From: Amanda Scholes on behalf of Planning.Responses
Sent: 10 August 2018 11:00
To: Planning Scanning
Subject: FW: Planning Application LU/189/18/PDH

I have been trying to contact you with reference to my neighbours planning application Mr Dean Jones, house no 48 Northway Road, Littlehampton, west Sussex BN17 7JX, for a single story extension without success.

Re: Formal Objection to Planning Application LU/189/18/PDH – 48 Northway Road, Littlehampton.

48 NORTHWAY ROAD, LITTLEHAMPTON
Existing details 01

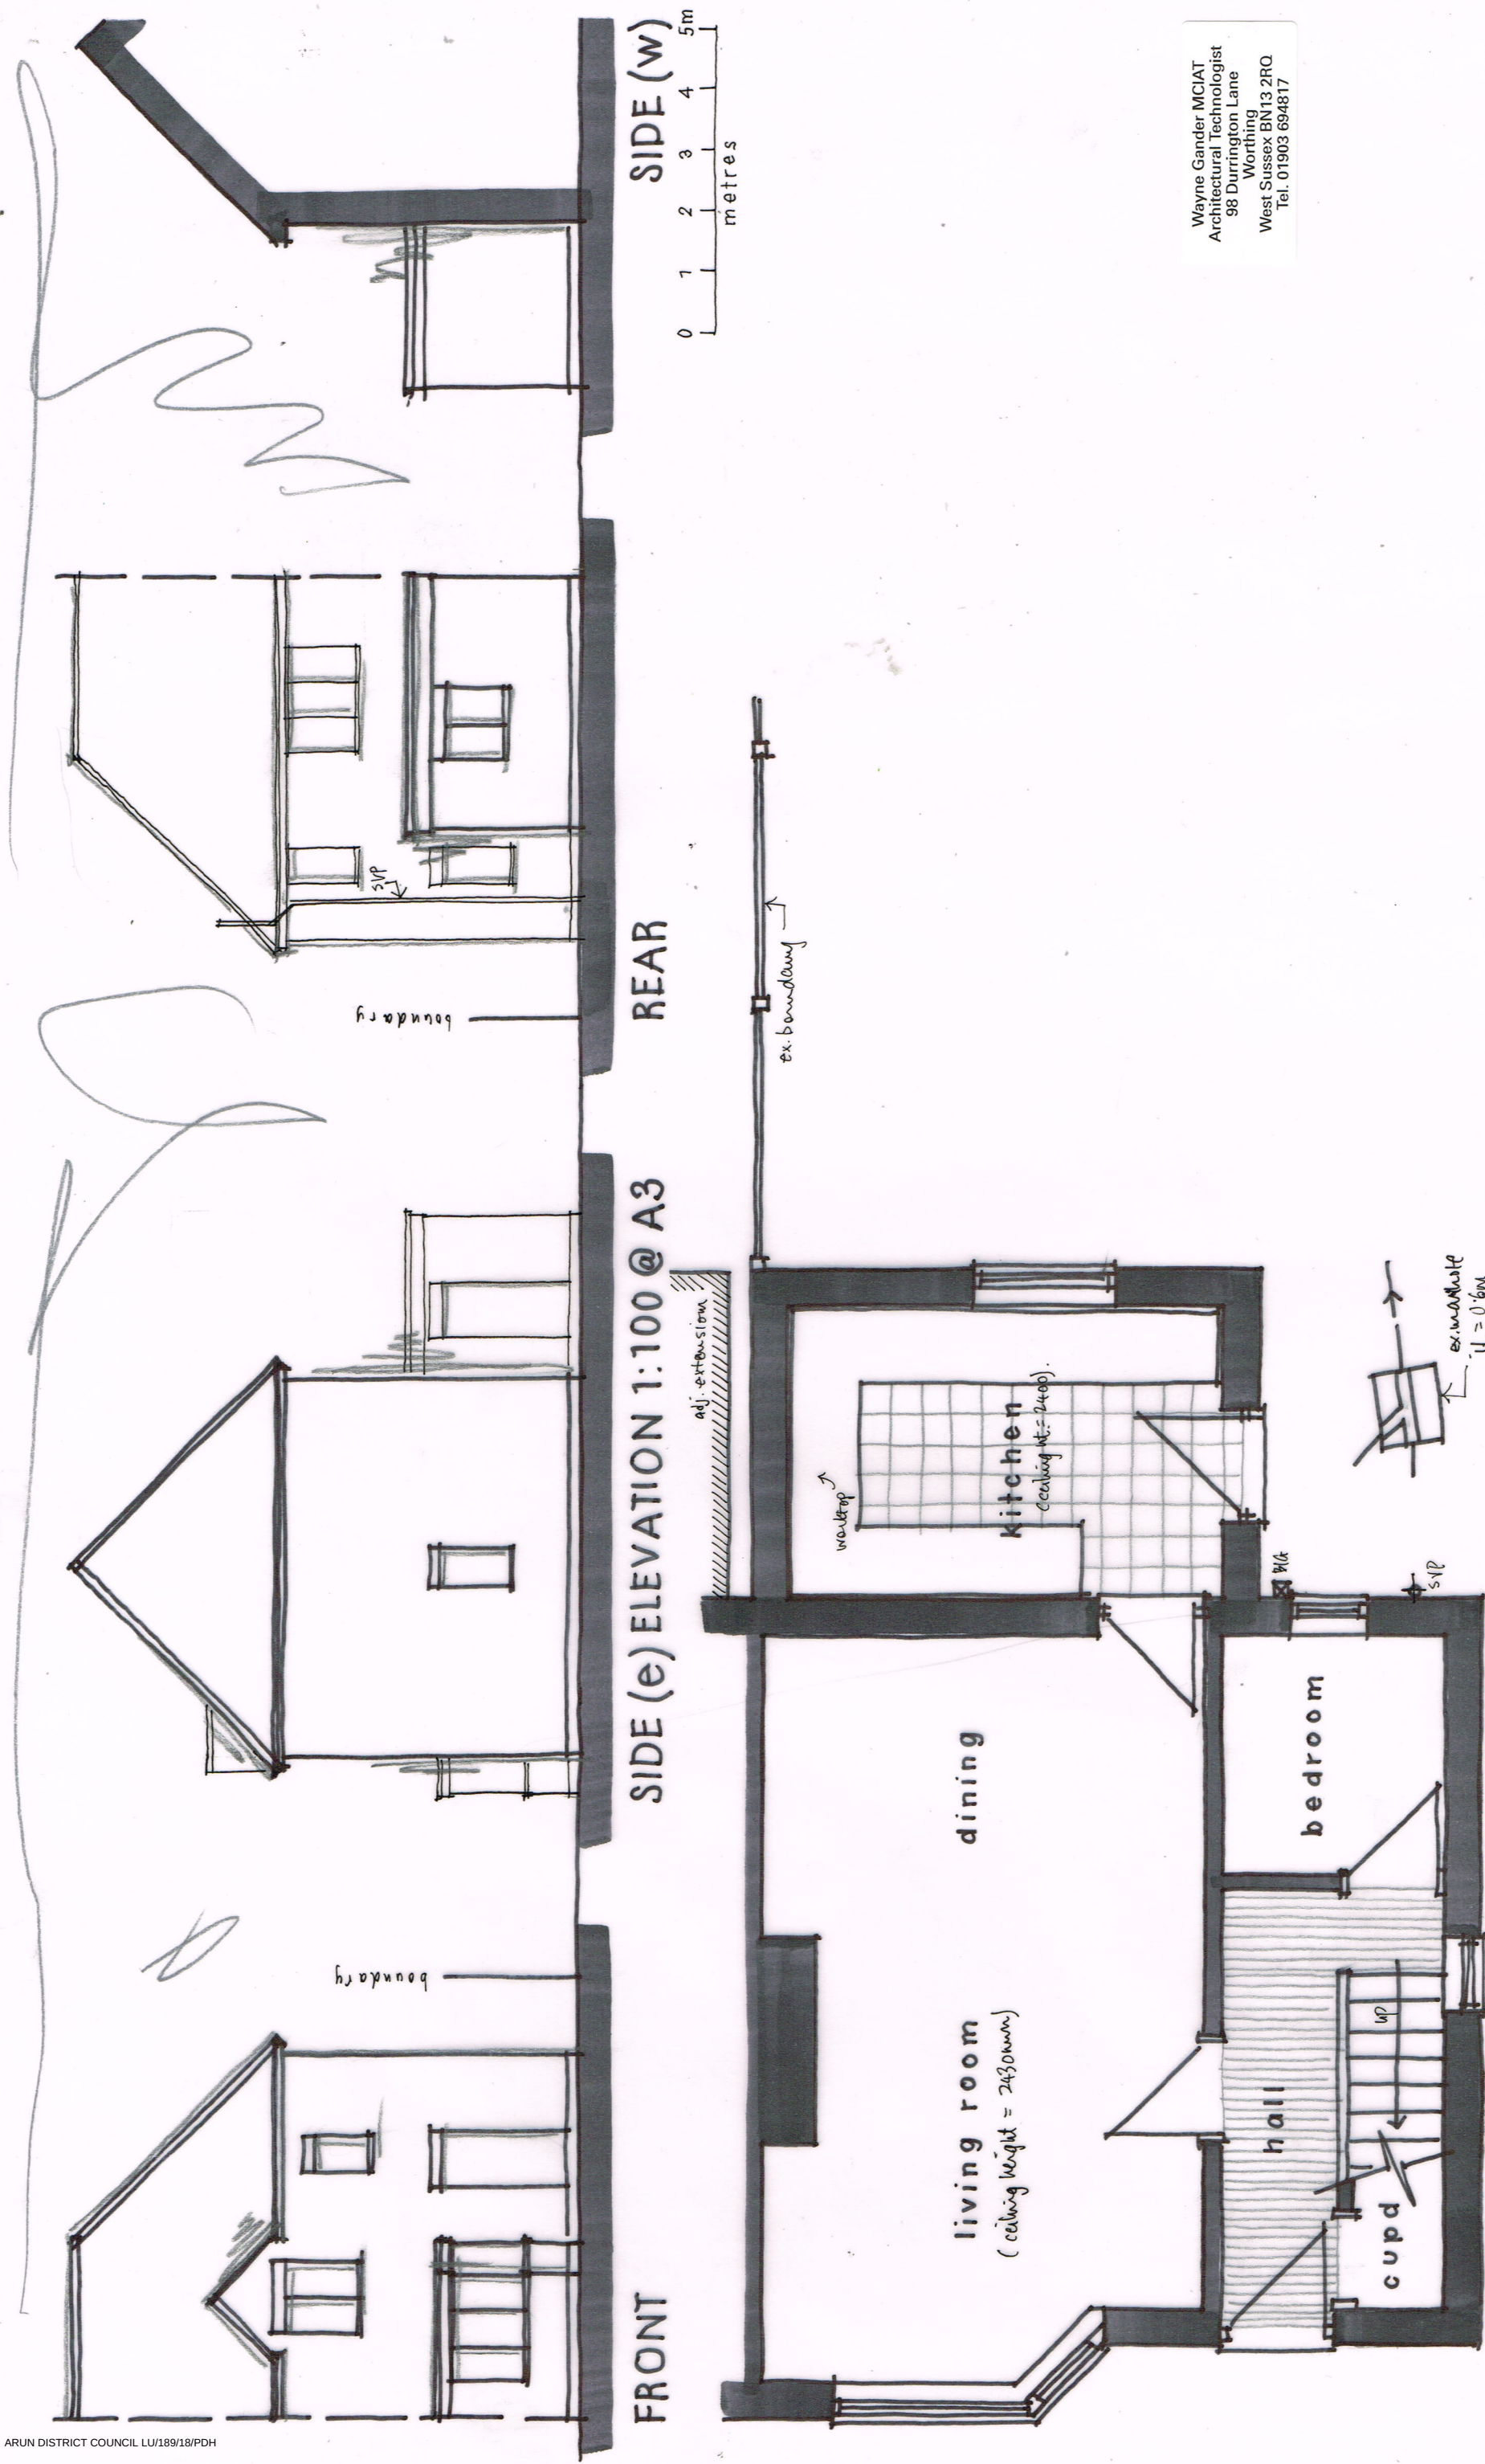
My concerns relate to Mr Dean Jones existing extension and their intention to build directly onto their existing extension wall, which currently overlaps, into my garden. I have had extensive discussions with Land Registry and they said they are unable to give an exact boundary line, as boundary lines change over time. When I moved in 31 years ago both houses had the existing extensions and the fence line has always been as it is currently.

Although in principal, I do not have any objections to Mr Jones proposed extension building, I am concerned that it could potentially cause damage to my double story extension whilst excavating footings. Building so close to the perceived boundary would block significant light to my property, particularly as it is a North-facing plot.

1. The plans submitted as part of the application, do not make specific reference to the correct and defined boundary that exists between both properties. I am of the opinion that this has been done to intentionally miss-lead. If the boundary as shown is correct, then the proposed extension can only be constructed by way of entering my property (e.g. concrete foundation bearing, scaffolding, guttering, roofing etc.). Even if the correct line of the boundary is such that it runs midway between the properties, there is still insufficient distance to allow construction without the need to enter my property. This would be the subject of a Party Wall agreement for which the Applicant has dismissed to provide and/or enter into. Further, if the brickwork, which is shown on the boundary line ever, required maintenance, this too could only be accessed by way of entering on my property. For the avoidance of doubt, I consider any such entrance to my property as Trespass, and will contact the relevant authorities should the need arise. Therefore, if the Application was to be passed (which it should not as currently proposed), it should only be done so with the strict condition that the external walls are constructed at least 1 metre away from the boundary line between both properties.
